Our Case Number: ABP-318573-23

Re: A proposed Road Development comprising of the N2 Slane By-Pass and Public Realm Enhancement Scheme
Within the Townlands of Slane, County Meath

**RE: Proposed Road Development comprising of the N2 Slane By-Pass and Public Realm Enhancement Scheme
Ref. 318573**

Figure 4.29: Public Realm Proposals for The Square

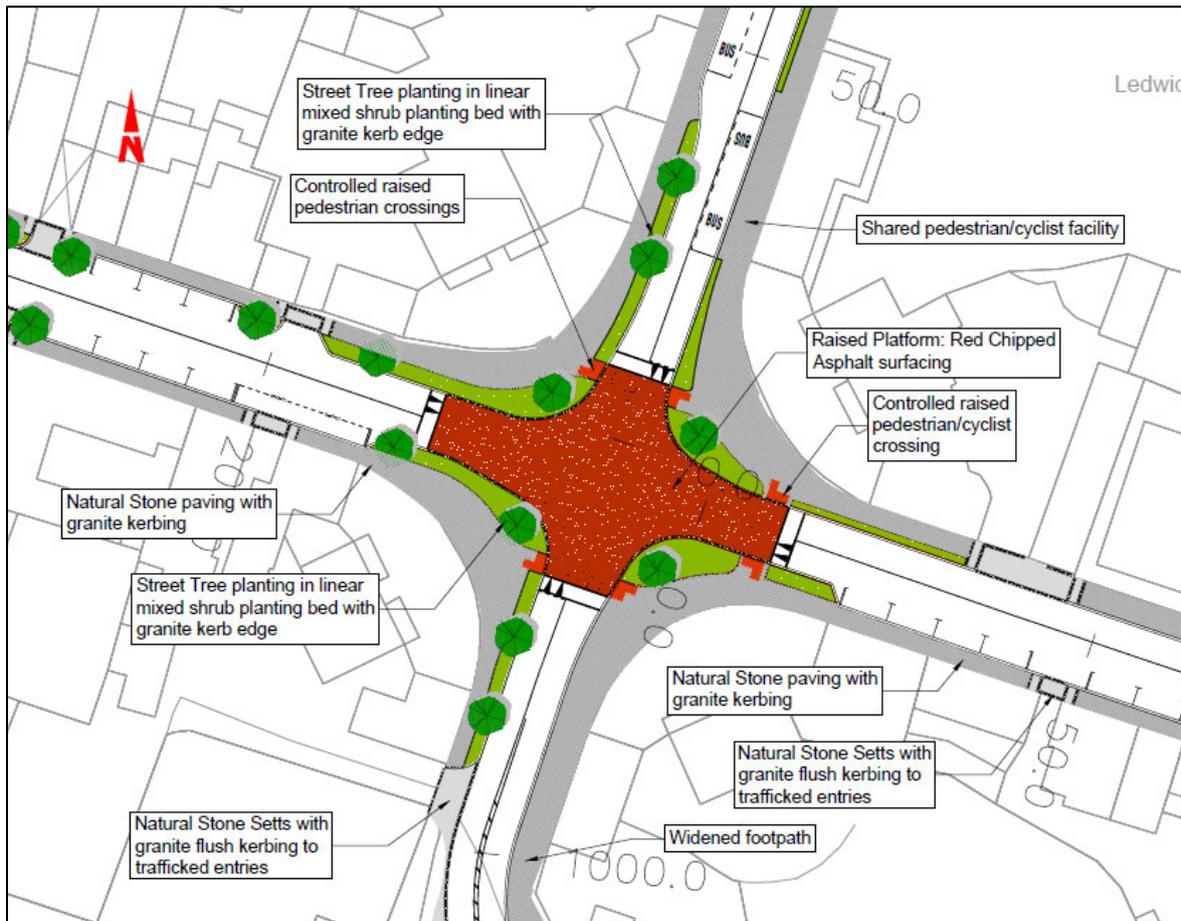
- The proposed use of 'Asphalt with red chipping' and 'Red Tactile Paving (Controlled Crossing)' would dominate views within The Square and would significantly compromise the character and setting of protected structures within the ACA.
- No detailed information is provided on the materials to be used for the proposed 'large unit paving' or 'medium unit paving' and so it is not possible to determine the visual impact of these proposed works.
- The purpose of the 'raised platforms' in the centre of The Square and at the proposed crossing points is unclear as is their visual impact.
- No details or design rationale are provided for the proposed 'soft landscaping area'.

It would seem that photomontages of the Slane Village ACA have not been included in Vol. 4 of the *EIA Report* though a limited number of these views have been included in a gallery on the website. These confirm concerns about the detrimental visual impact of the planned works with wide expanses of red surface finishes dominating the urban space.

For the proposed bypass of Slane to succeed in attracting investment into the village's built heritage and promoting sensitive improvements, the Irish Georgian Society recommends that an RIAI accredited Grade 1 Conservation Architect be engaged to assist with devising a suitably sympathetic design for The Square.
